**SUBMISSION TO THE DEPARTMENT OF PLANNING AND INFRASTRUCTURE ON THE PROPOSED
NORTH WEST RAIL LINK (NWRL)**

Application Number: SSI-5100

Whilst I support in principle the construction of the NWRL to provide much needed public transport to the rapidly growing housing areas of north west Sydney and to reduce the pollution and congestion associated with road transport, I object to the following regarding the Cheltenham Intermediate Services Facility.

Figure 6.11 Cheltenham Services Facility light vehicle access and egress

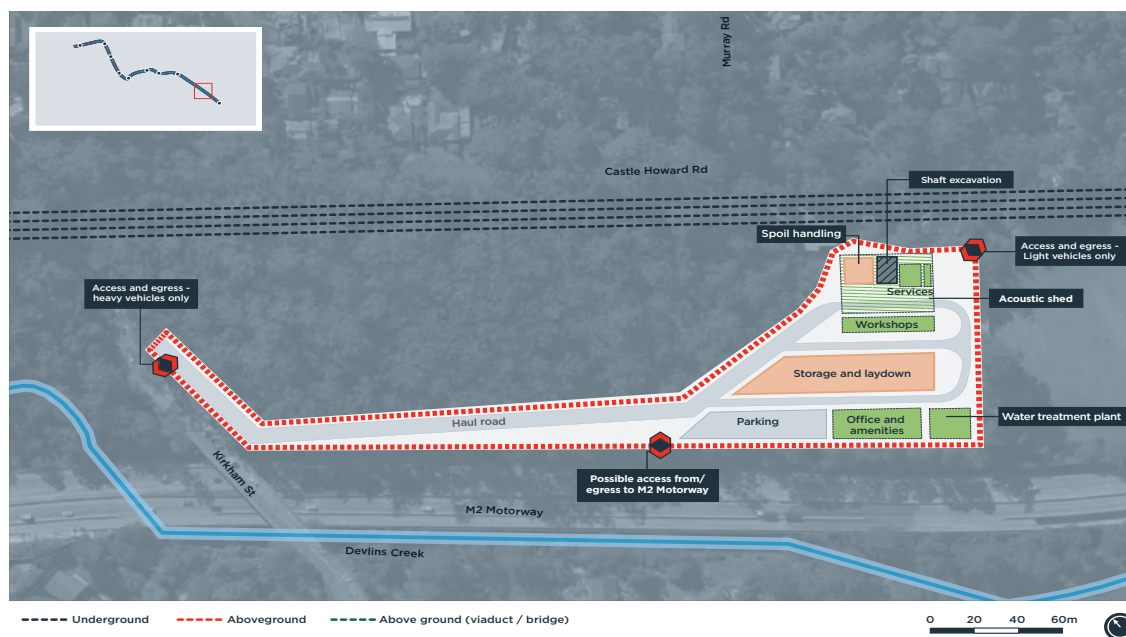
1. The option to construct a new two lane paved road through the Castle Howard Conservation Reserve to Kirkham Street (or Castle Howard Road) near the bridge over the M2 to allow trucks to remove spoil during construction and light vehicle access during operation of the facility will permanently destroy valuable Blackbutt Gully forest.

5. Should the roadway be built, the local streets (Kirkham Street, Castle Howard Road, Murray Farm Road and the bridge over the M2) are narrow, winding and congested and would not be suitable for trucks and, in the event of an emergency, large numbers of emergency vehicles.

I therefore ask that you adopt the alternative option of access to the site for construction and emergency vehicles be via new on and off ramps from the M2 motorway. The current widening and reinstatement of the breakdown lane should allow this access. It is the only practical way to move trucks in and out of the site. In the event of an emergency, many emergency vehicles would need quick access to the site from areas outside Beecroft and Cheltenham as it only has one fire engine.
